**Consultation Response from KC,
Highways Development Management****2024/92112 74, Wakefield Road, Lepton, Huddersfield, HD8 0BL****Demolition of existing dwelling and erection of replacement dwelling****Date Responded: 16-9-2024.****Responding Officer: Mark Berry.****Responding Ref: 11-12SE-10.**

This application seeks approval to the demolition of an existing 3 bedroomed detached bungalow with a single detached garage and the erection of a replacement 5-bedroom detached house with attached double garage at 74, Wakefield Road, Lepton, Huddersfield.

Proposed Site Roof Plan 1:200

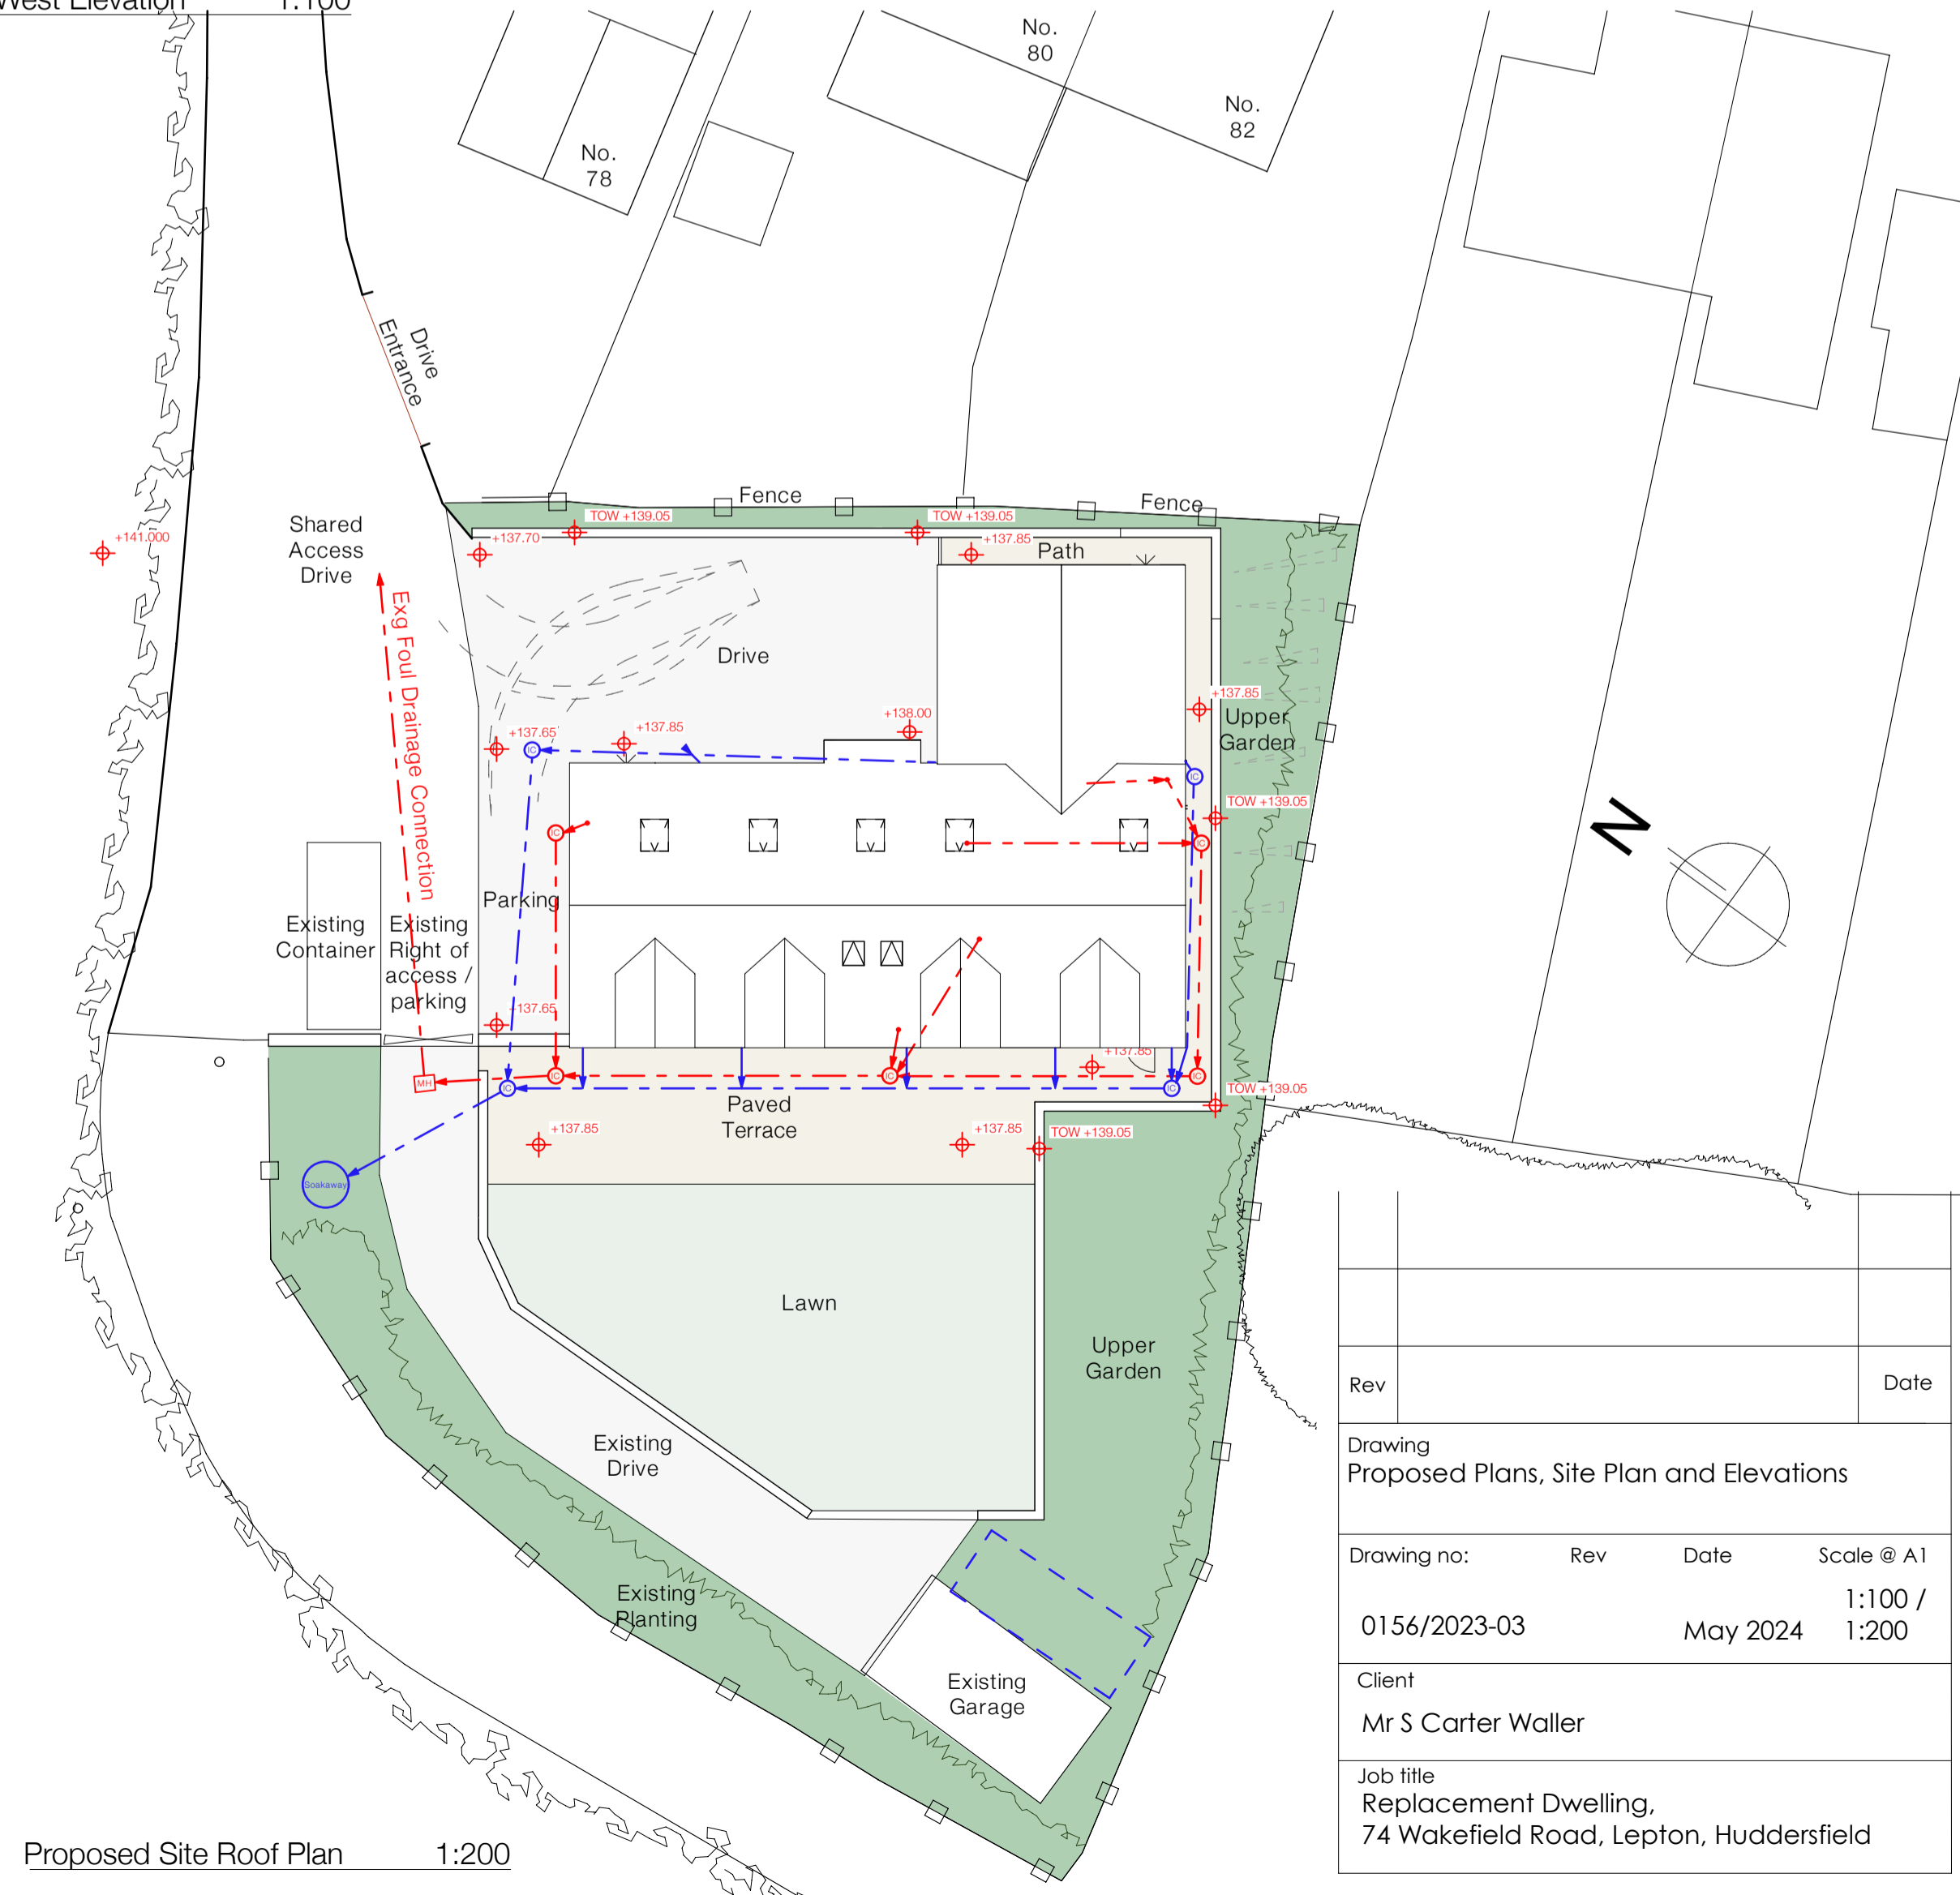
The existing access which is shared with 78 Wakefield Road is to be retained and used as access for the proposed new dwelling.

The proposals include ample off-street parking with internal vehicle turning.

Given that this is a replacement dwelling which utilises an existing access and ample of-street parking is to be provided Highways Development Management has no objection to these proposals.

Prior to the development being brought into use, the approved vehicle parking areas shall be surfaced and drained in accordance with the Communities and Local Government; and Environment Agencies 'Guidance on the permeable surfacing of front gardens (**parking areas**)' published 13th May 2009 (ISBN 9781409804864) as amended or superseded; and thereafter retained throughout the lifetime of the development.
